Current Zoning: R-MH LWPA LLWPA (residential manufactured housing, Lake Wylie Protected Area, Lower Lake Wylie Protected Area)
Proposed Zoning: I-2(CD) LWPA LLWPA (general industrial, conditional, Lake Wylie Protected Area, Lower Lake Wylie Protected Area)

Approximately 10.918 acres located on the southern side of John Gladden Road, north of Wilkinson Boulevard, and west of Sam Wilson Road

The petition proposes to rezone site to I-2(CD) to develop the site for off-site parking and outdoor storage.

**RZ-1.0**

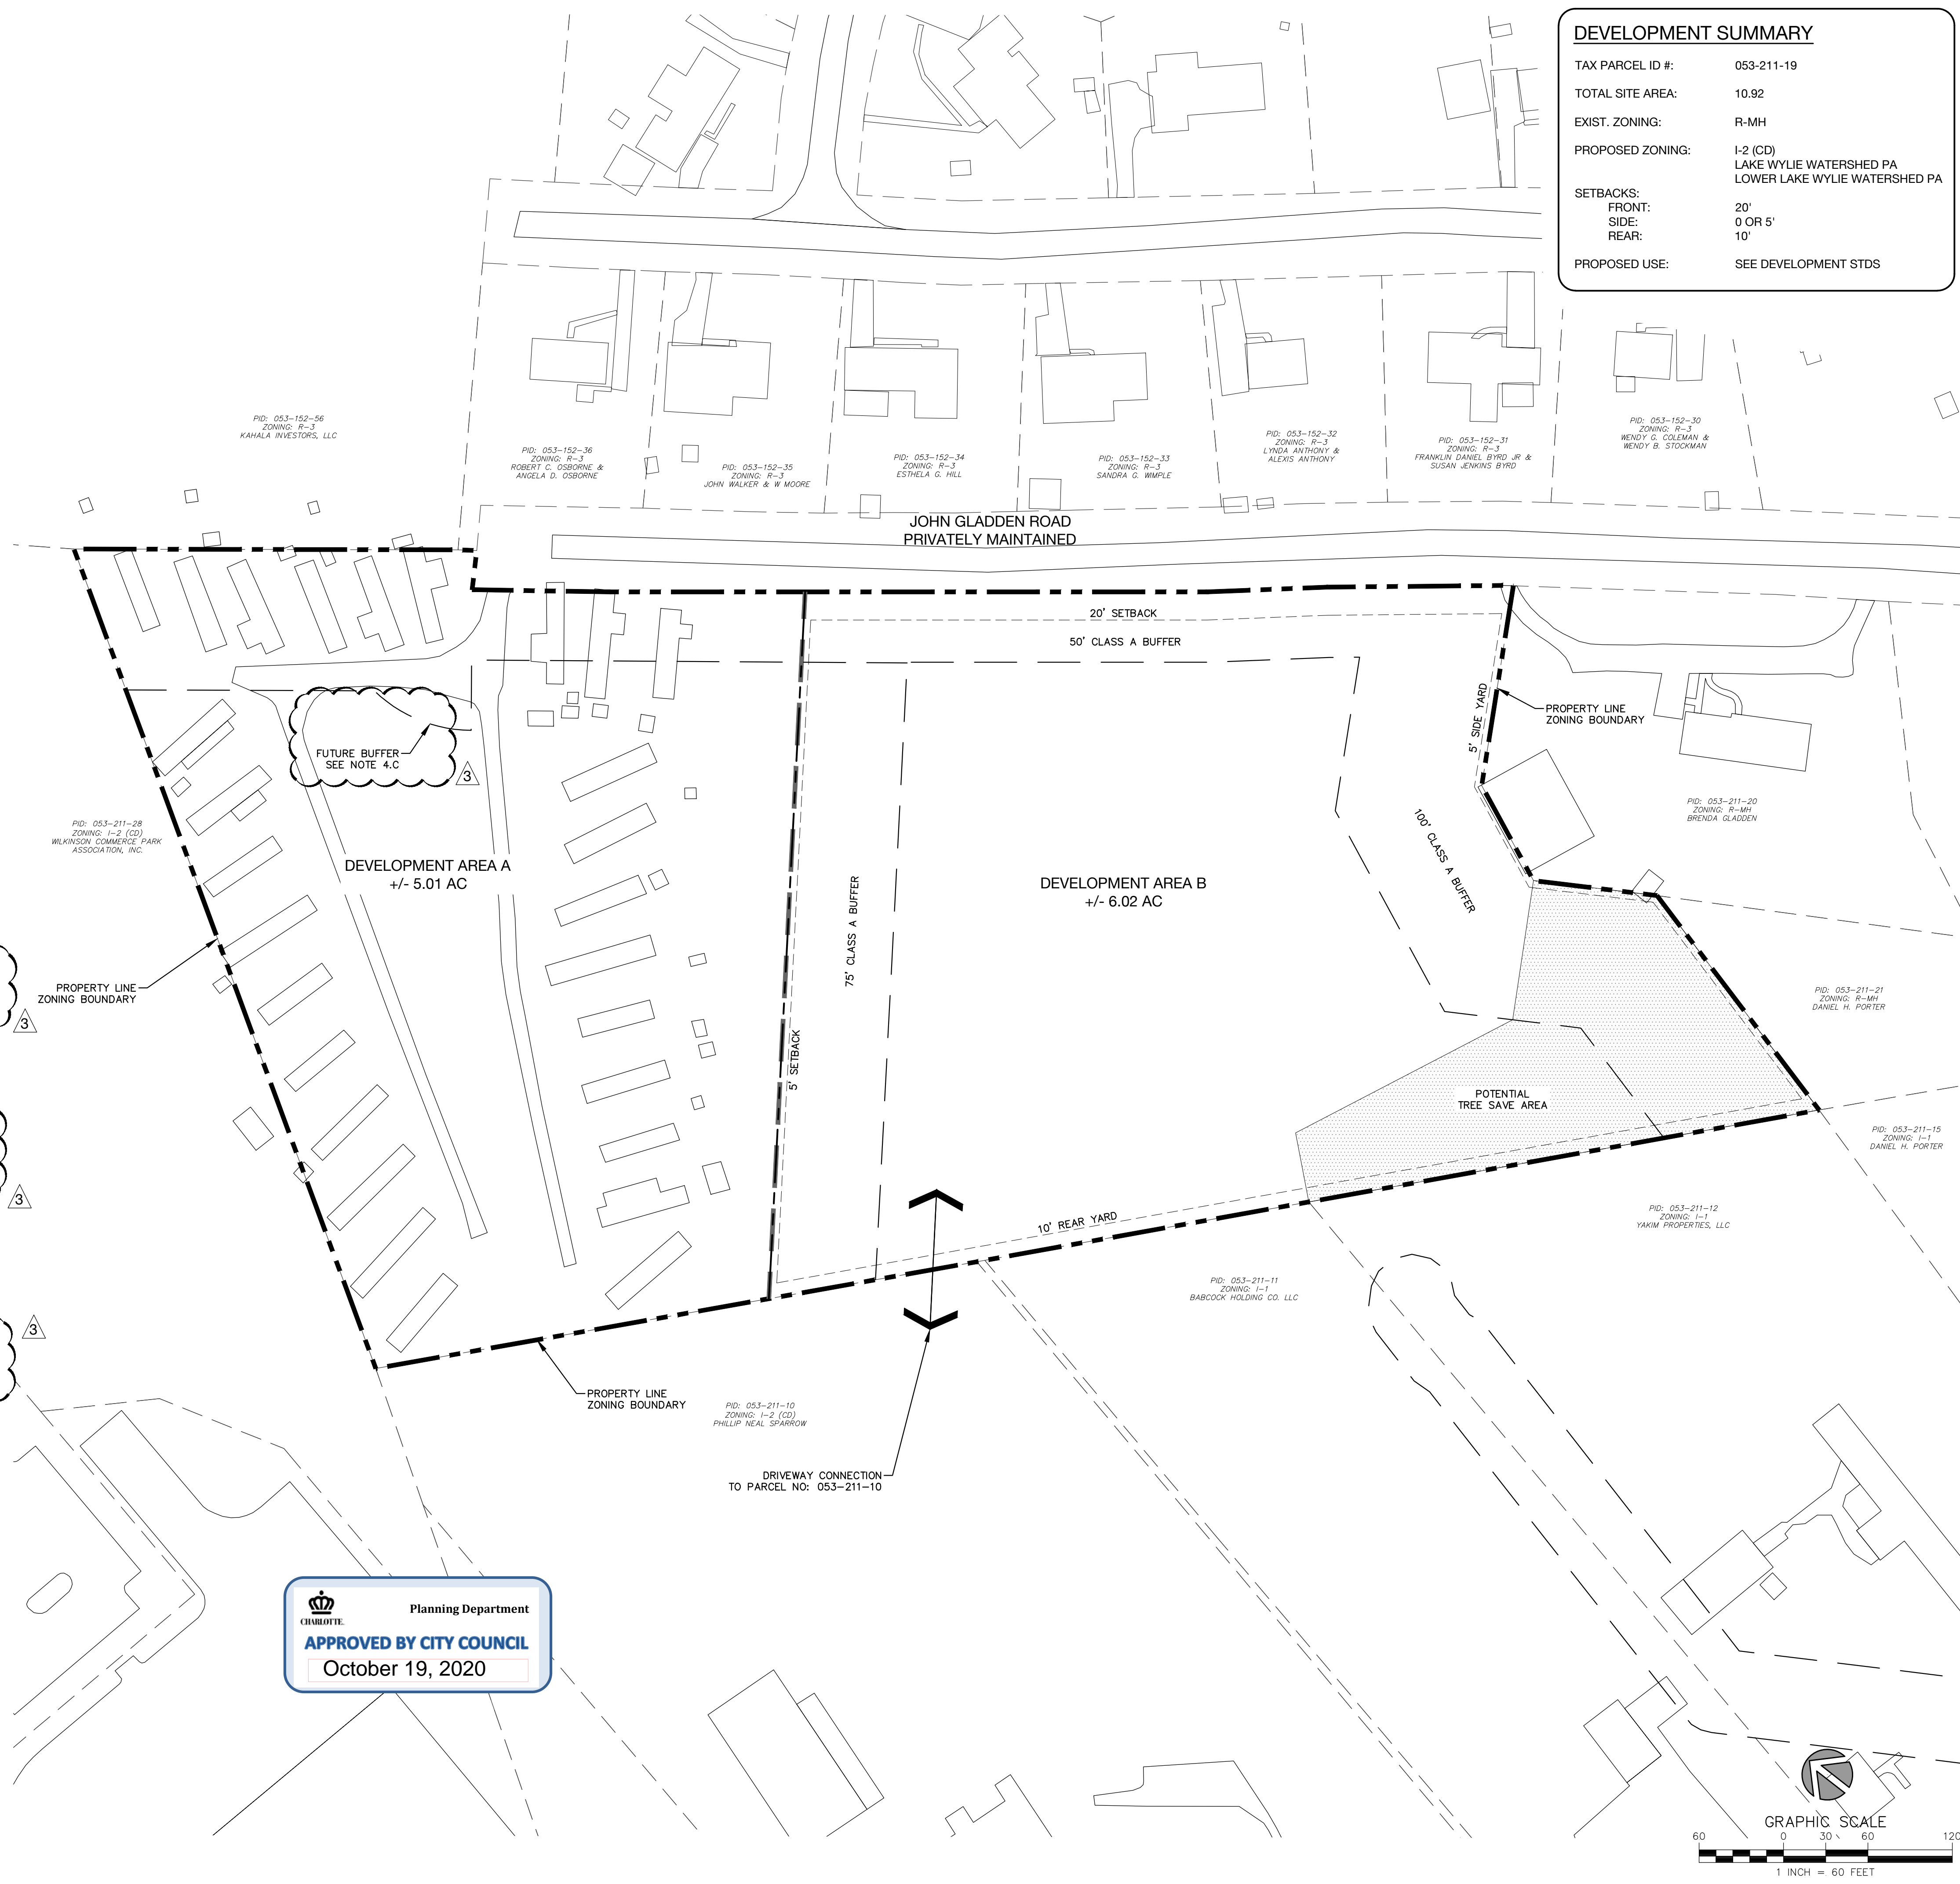
- ~~1. Will need to show required future buffer adjacent to R-3 single family in Development Area A.~~

- ~~2. The petitioner should revise the site plan and conditional notes, in reference to Sections 3.A. and 3.B, to establish and record a cross access easement across Tax Parcel Nos. 053-211-07 and 053-211-10 to Wilkinson Boulevard. Access agreement for all three parcels in the event that one or more parcel(s) is sold to another individual/entity for access to be maintained to Wilkinson.~~

ADDRESSED

ADDRESSED
